02/09/2022
Your Ref: TR010062

A66 Northern Trans-Pennine: Response to Procedural Decisions (Rule 9 Letter)

Annex 1: Response to matters arising from acceptance

Drawing Number HE565627 - AMY - HAC - S09	Originator - DR - YL - 00001	Volume Type Role Number
---	--	---

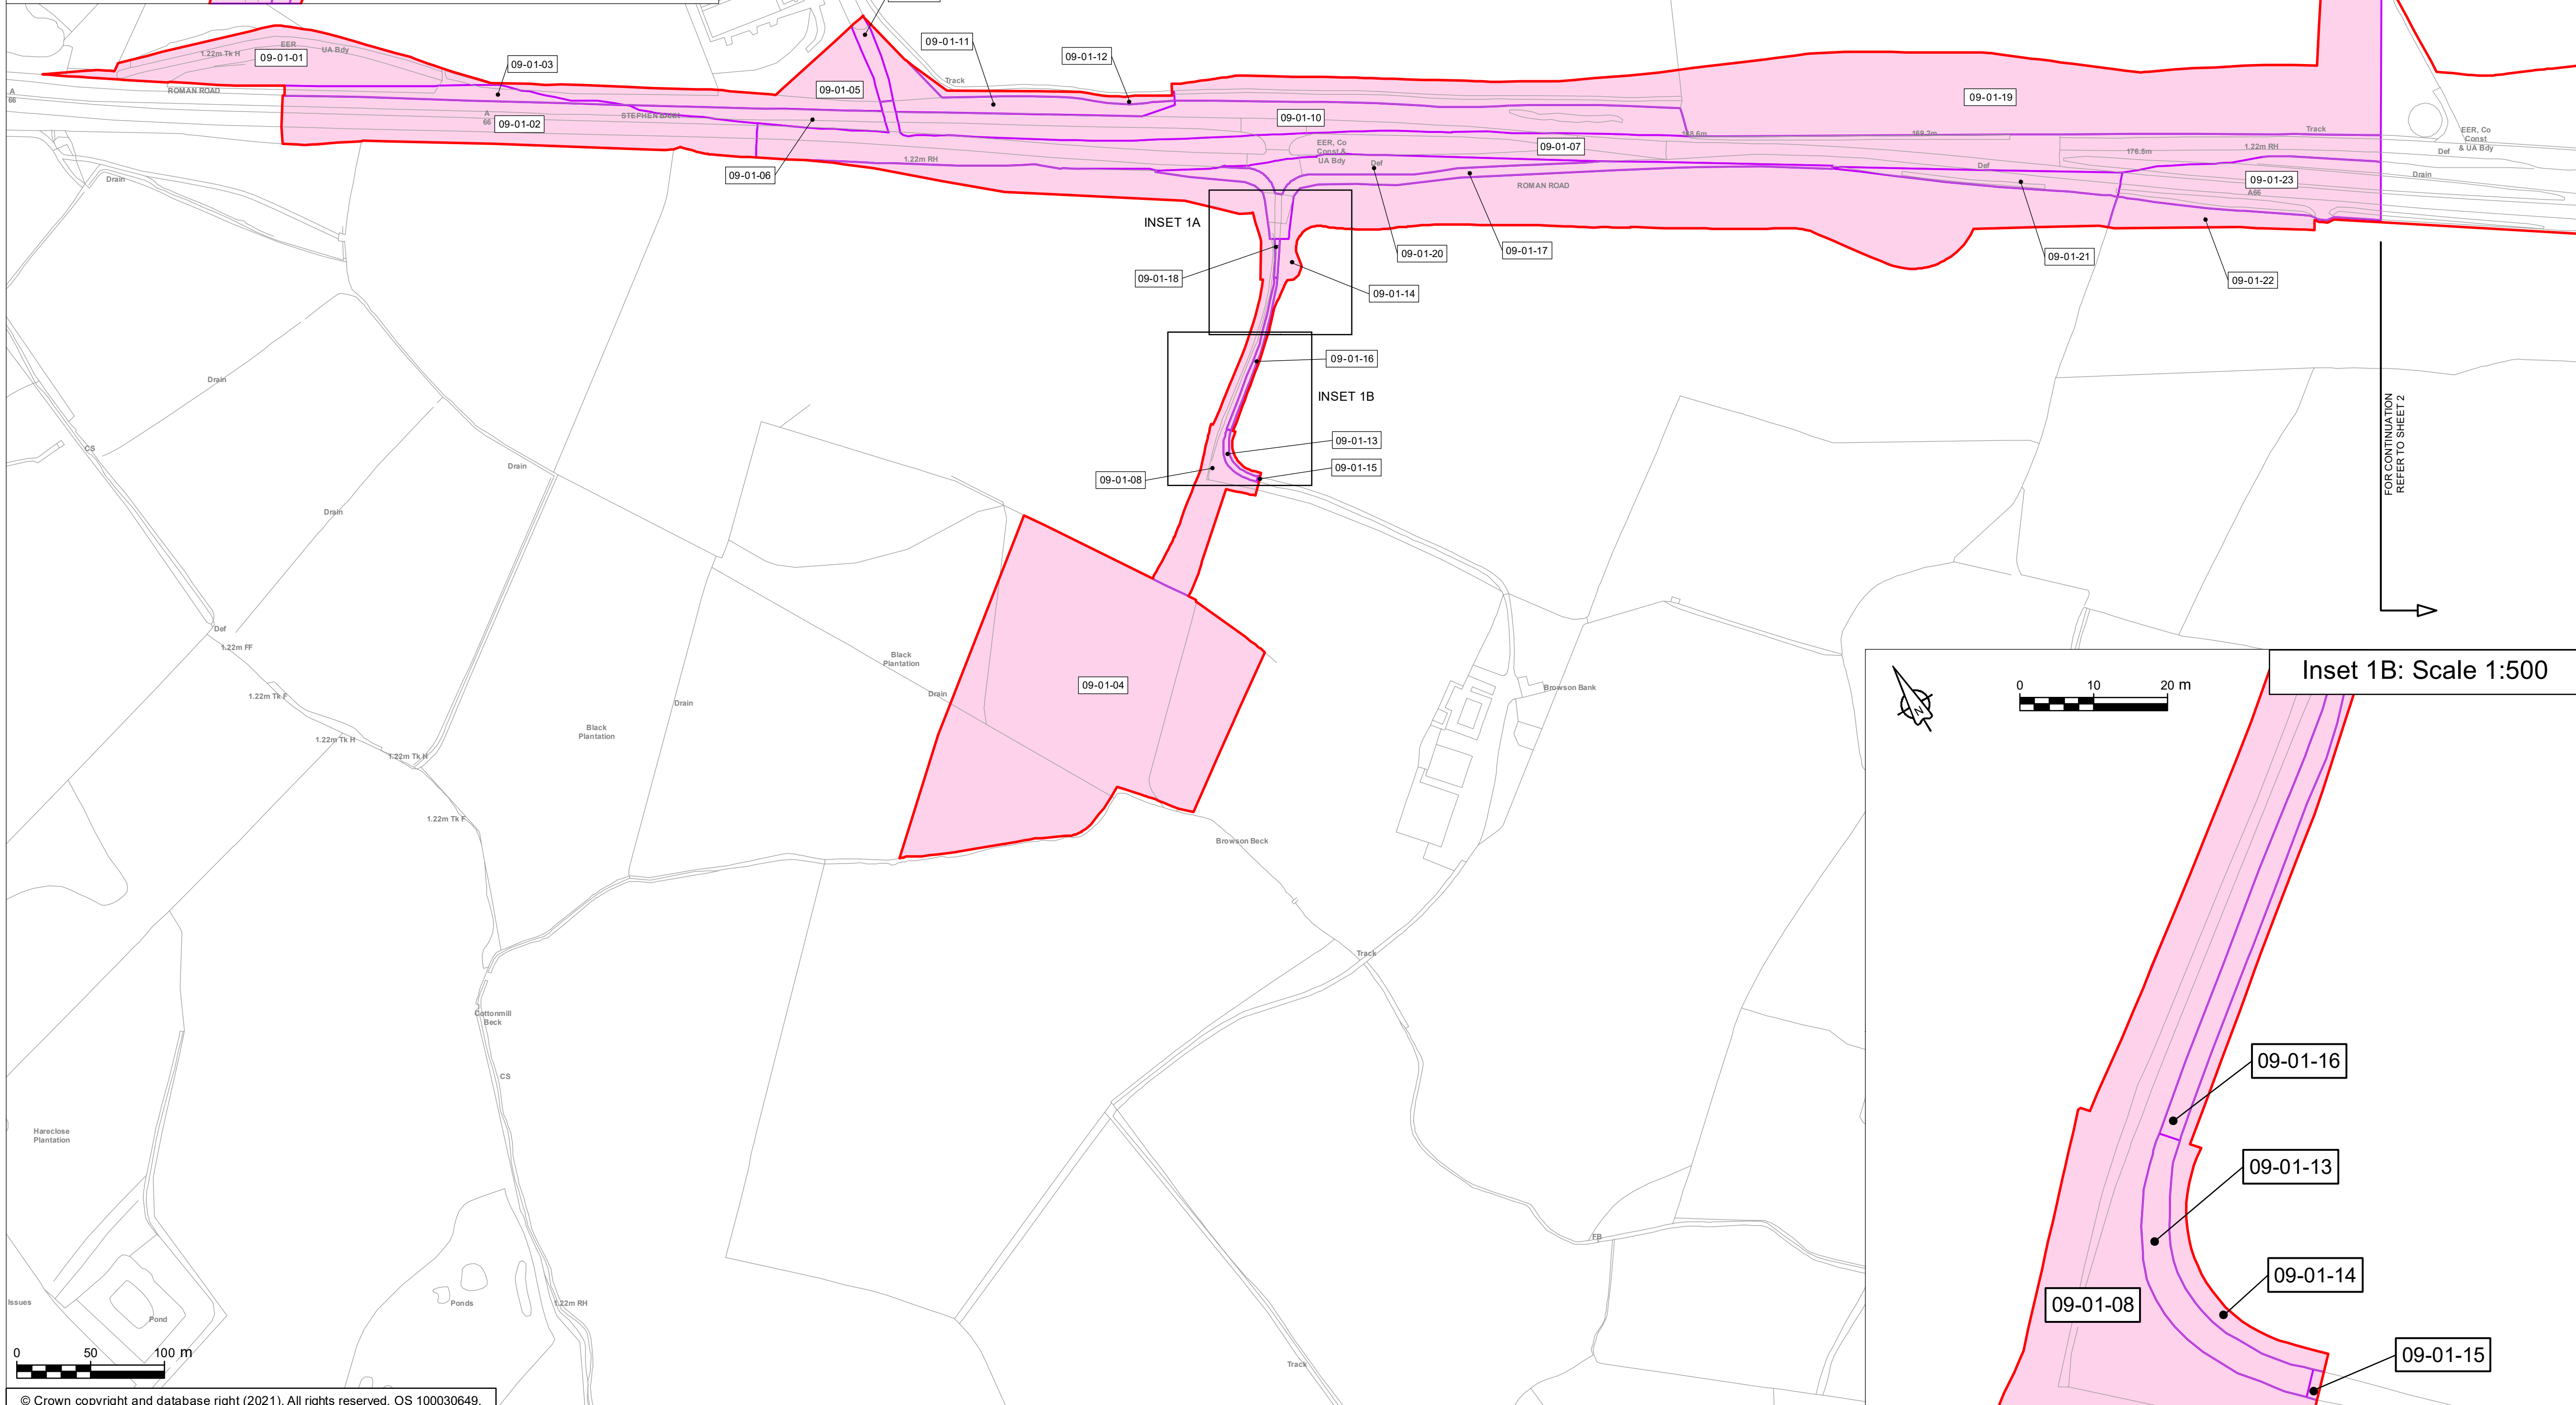
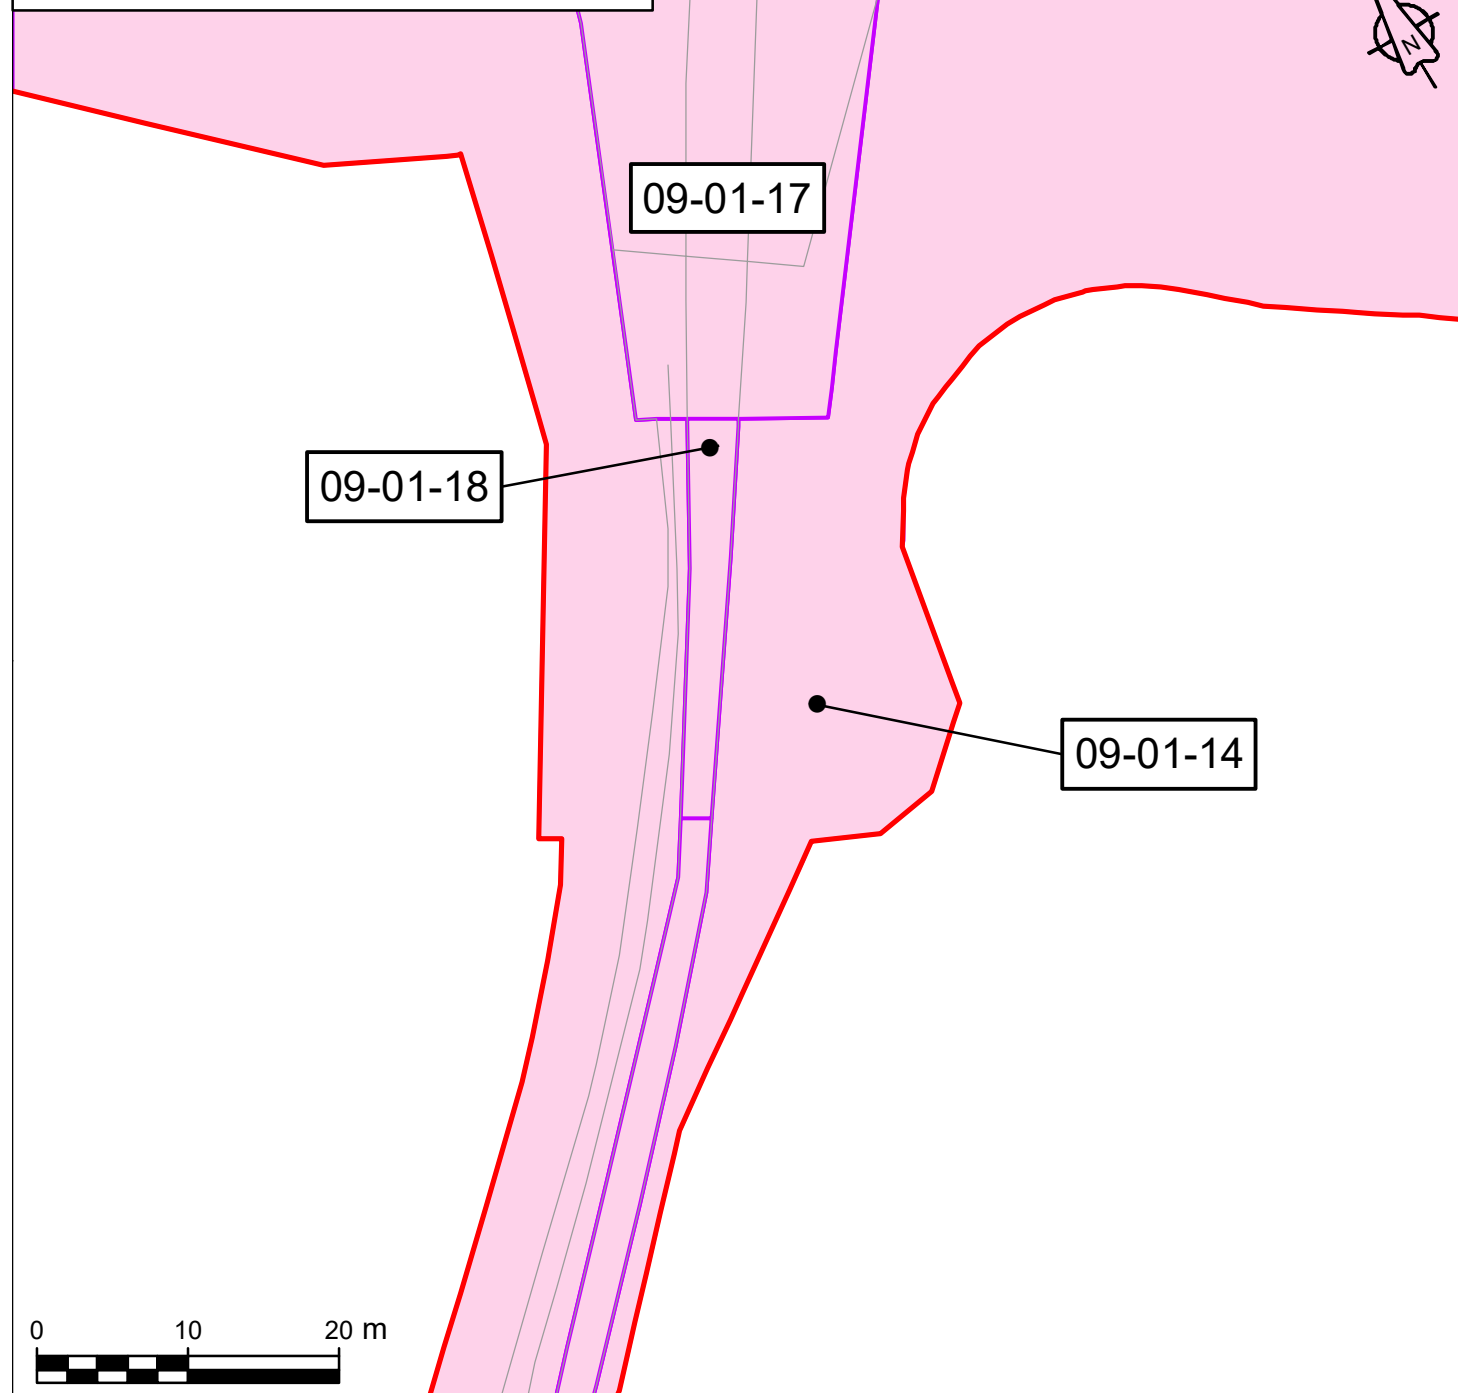
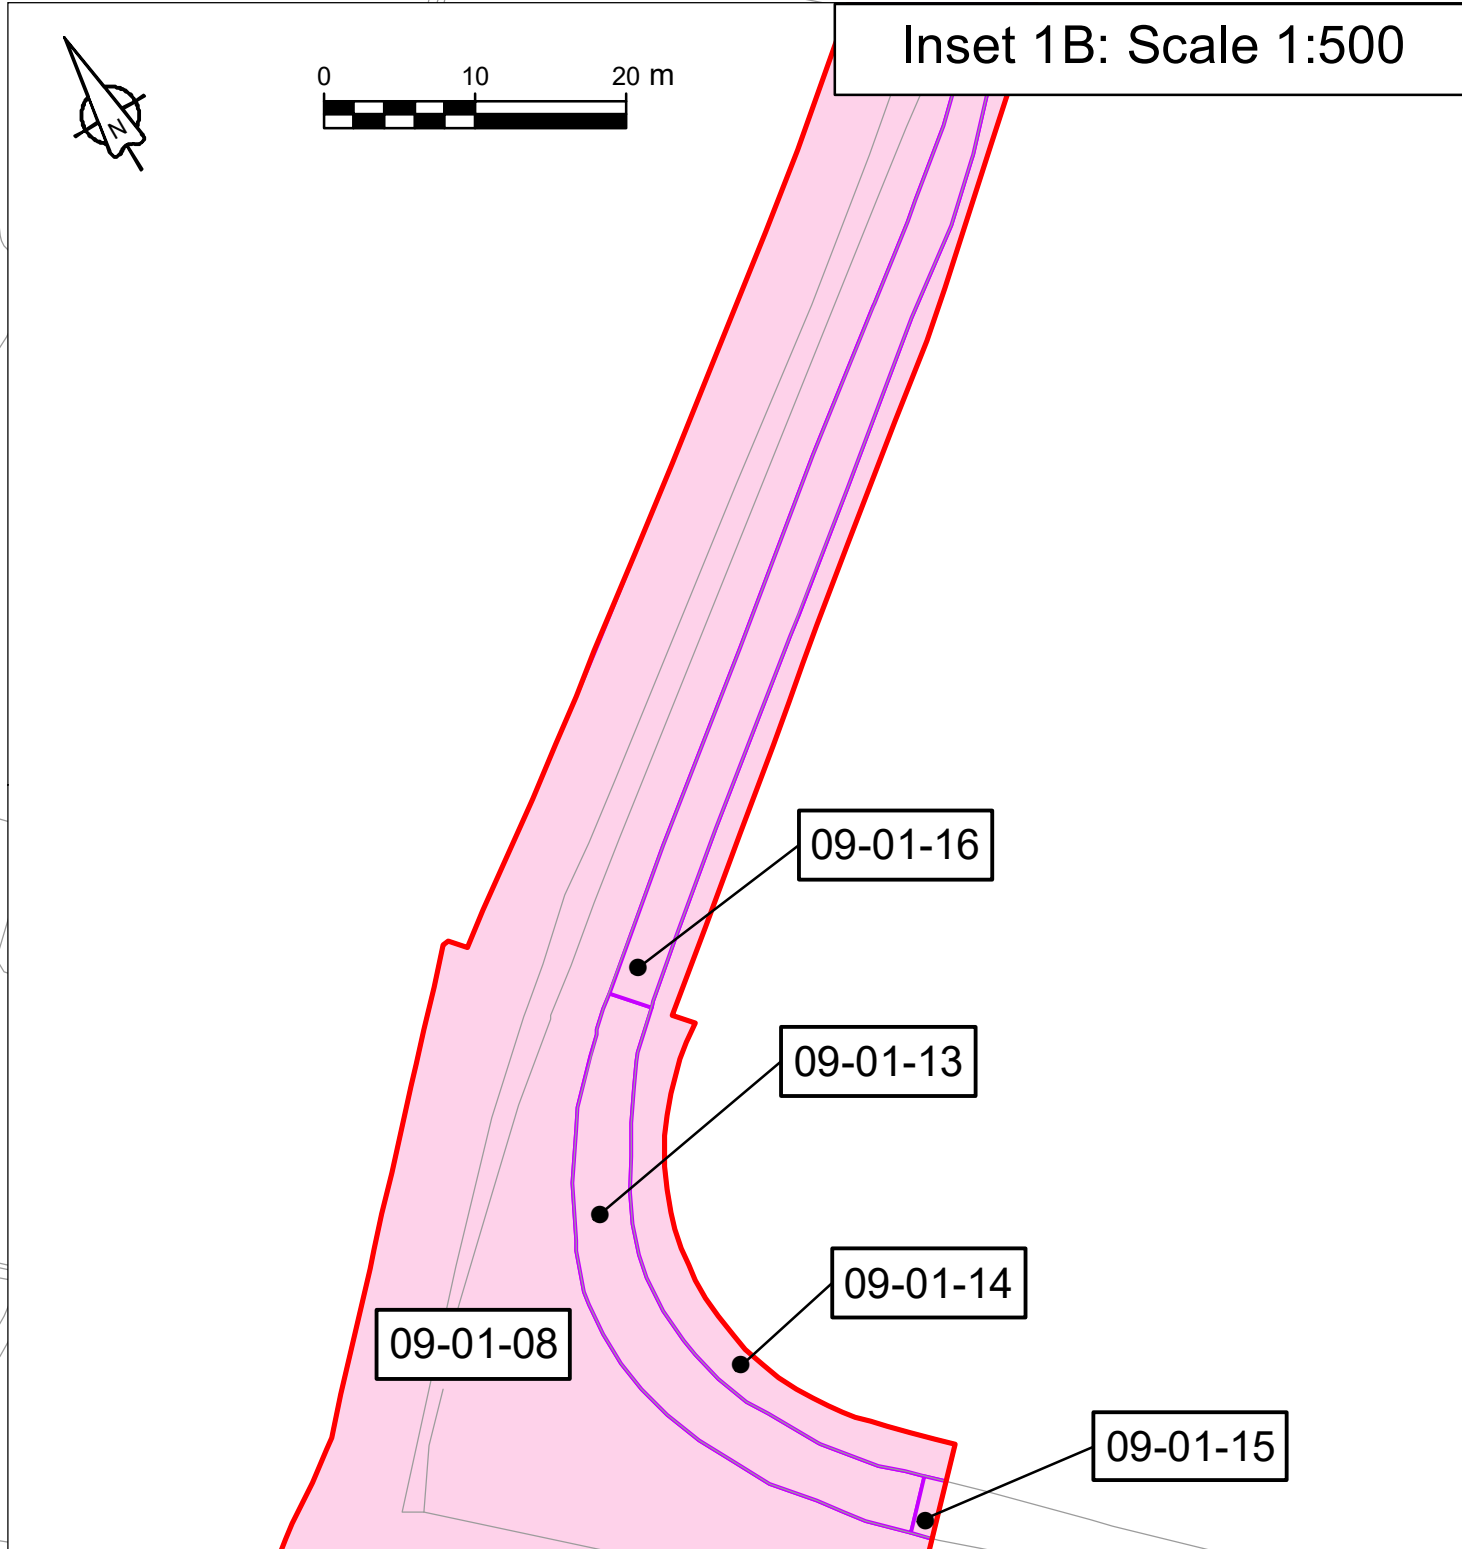
Sheet 1: Plot 09-01-22 refers to plot Northeast of Sykelands Farm, Dalton, Richmond DL11 7HE. Applicant is asked to check this as no reference to Sykelands Farm is found.	The description of Plot 09-01-22 incorrectly referenced Sykelands Farm; this has been corrected to refer to Browson Bank Farm, Dalton, Richmond DL11 7HE in the updated BoR.
